CITY OF ALBUQUERQUE

RE: **Beehive Village at San Pedro-phase 2**
6401 Corona NE
Requested for Permanent C. O. – Not Accepted
Engineers Stamp Date 6/23/15 (C18D016A)
Certification dated: 5-24-16

ENGINEER'S SEAL	BEEHIVE HOMES	DRAWN BY WCVJ
DATE 6-21-11	GRADING AND DRAINAGE PLAN	DATE 6-21-11
2119-1000-6-01-10	Rio Grande Engineering	SHEET # 2
1806 CENTRAL AVENUE SUITE 201 ALBUQUERQUE, NM 87106 (505) 872-0999	DAVID SOULE P.E. #14522	JOB # 2119

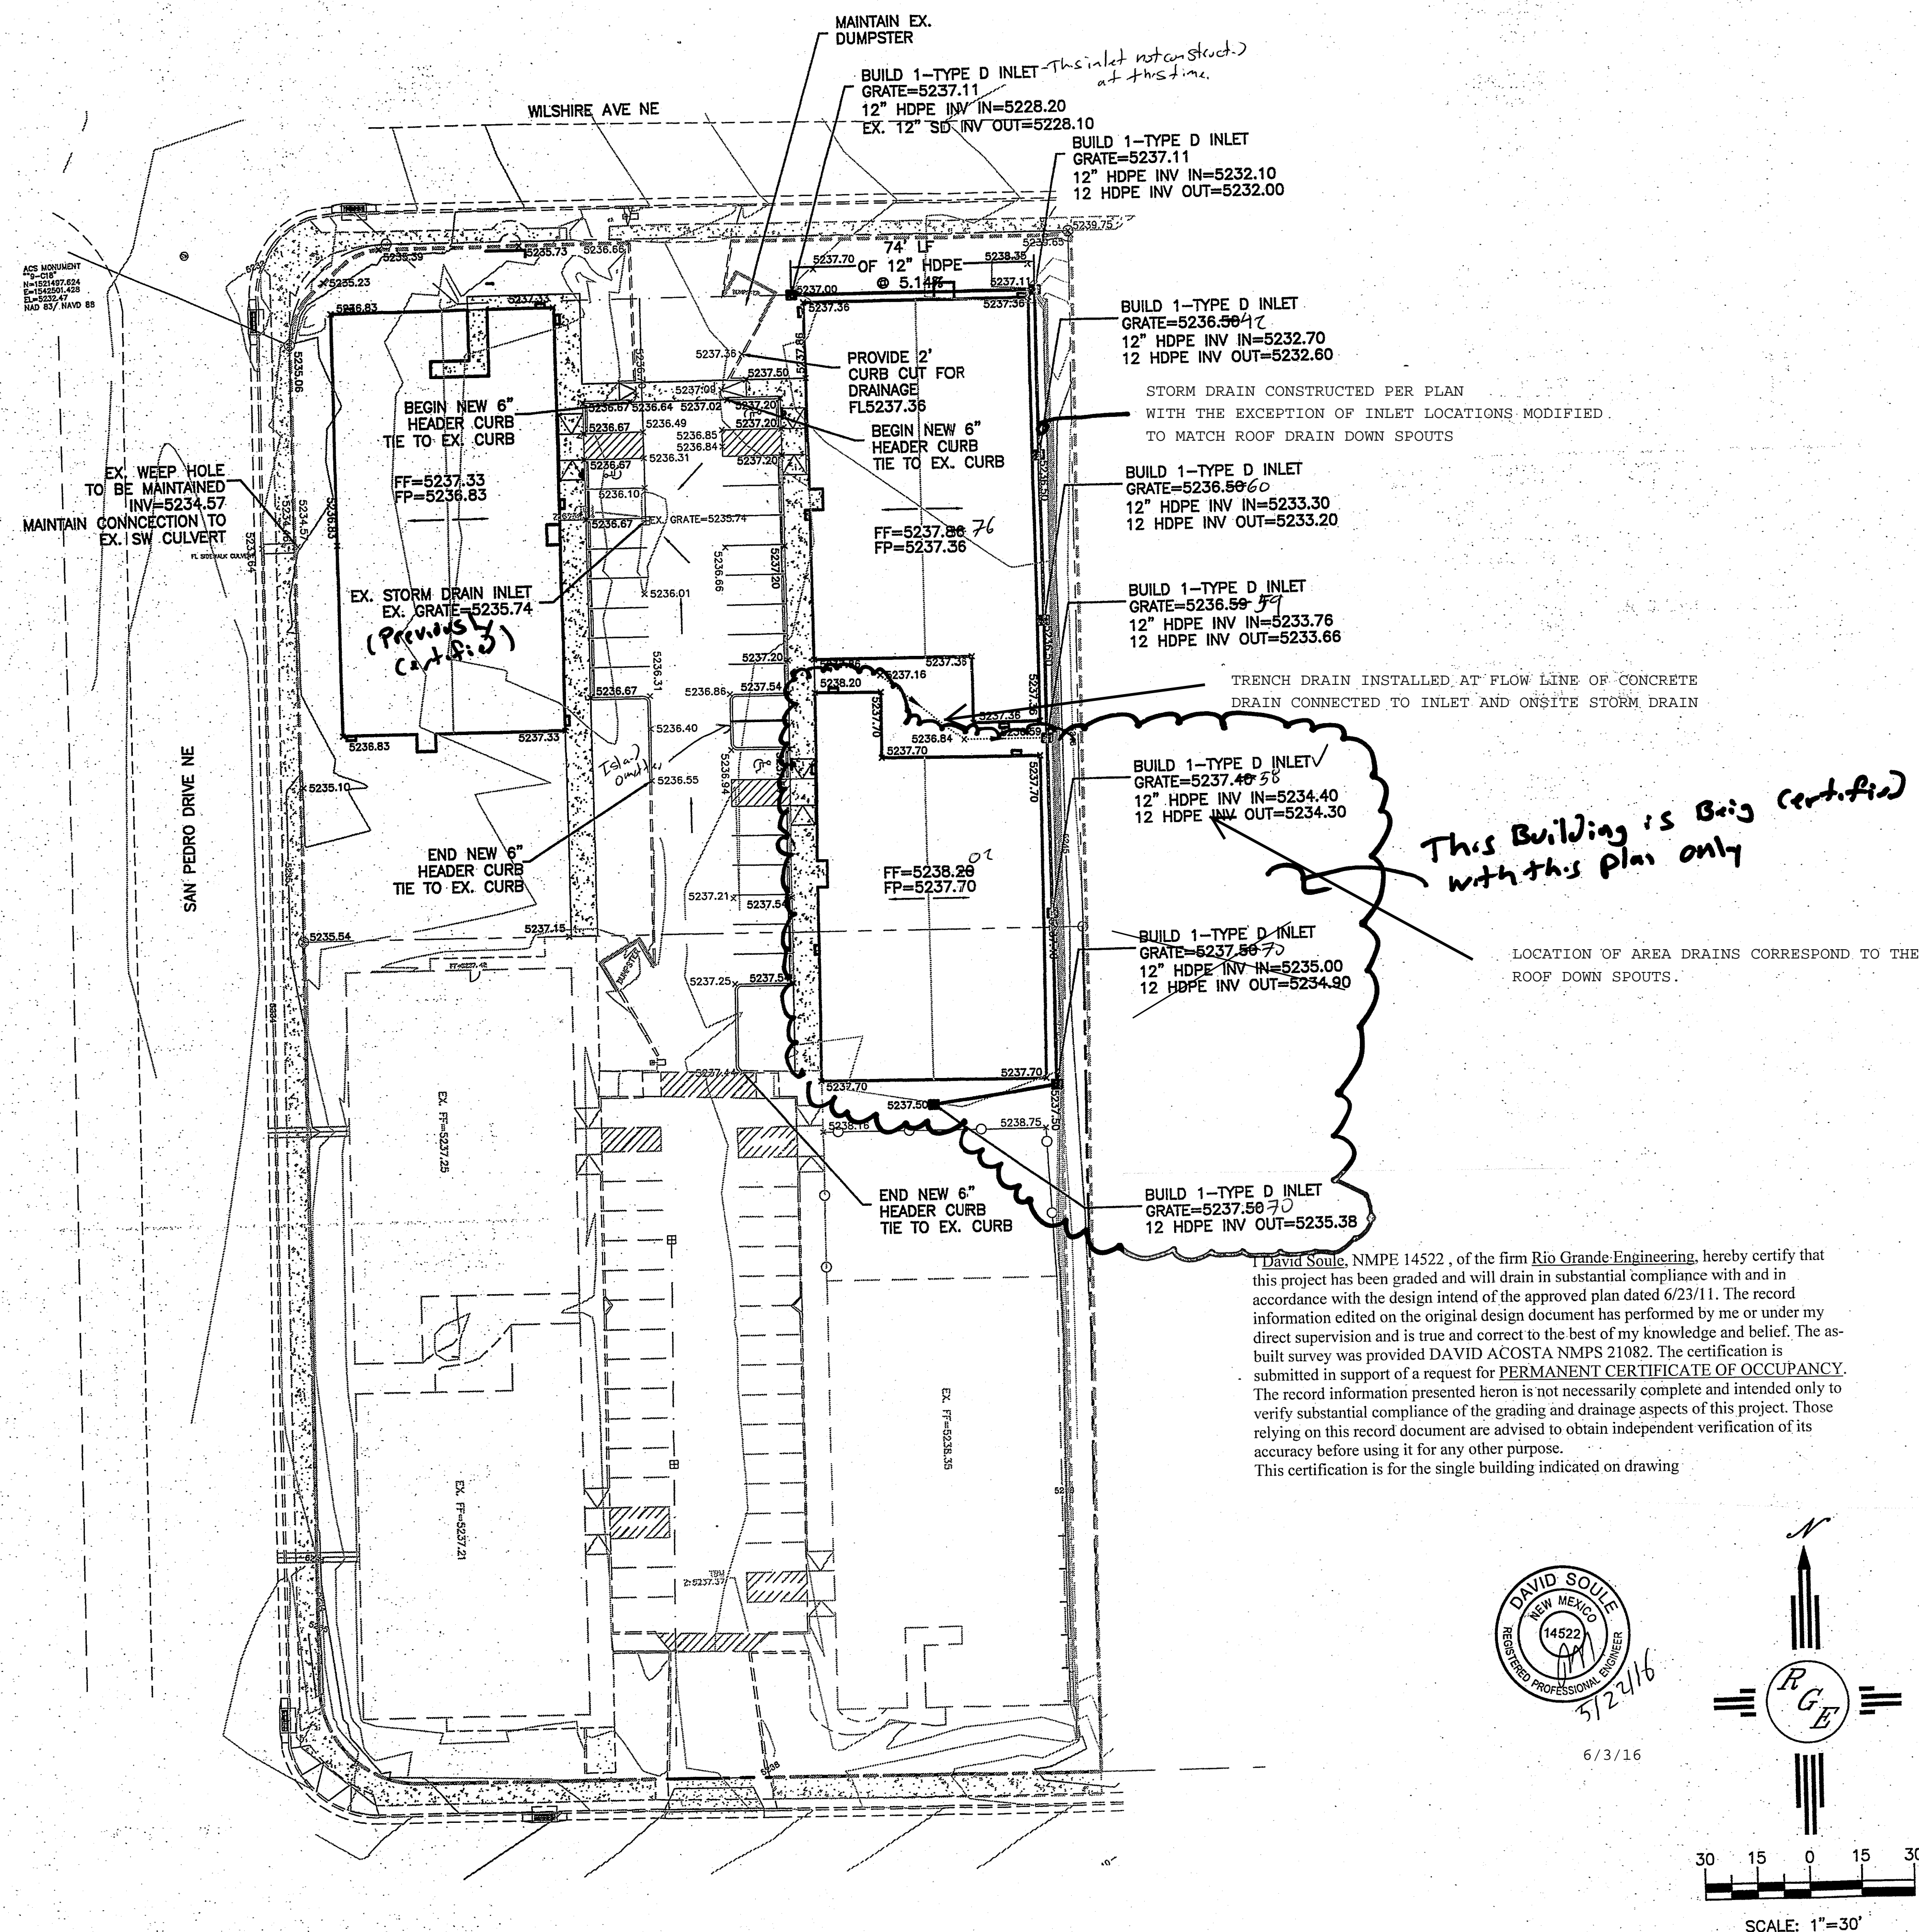
- The 12" HDPE INV on the SE corner of the building is missing.
- There is an open trench and construction materials scattered on the north end
- The as-built submitted is not the approved drawing. It does not have your engineer's stamp date.
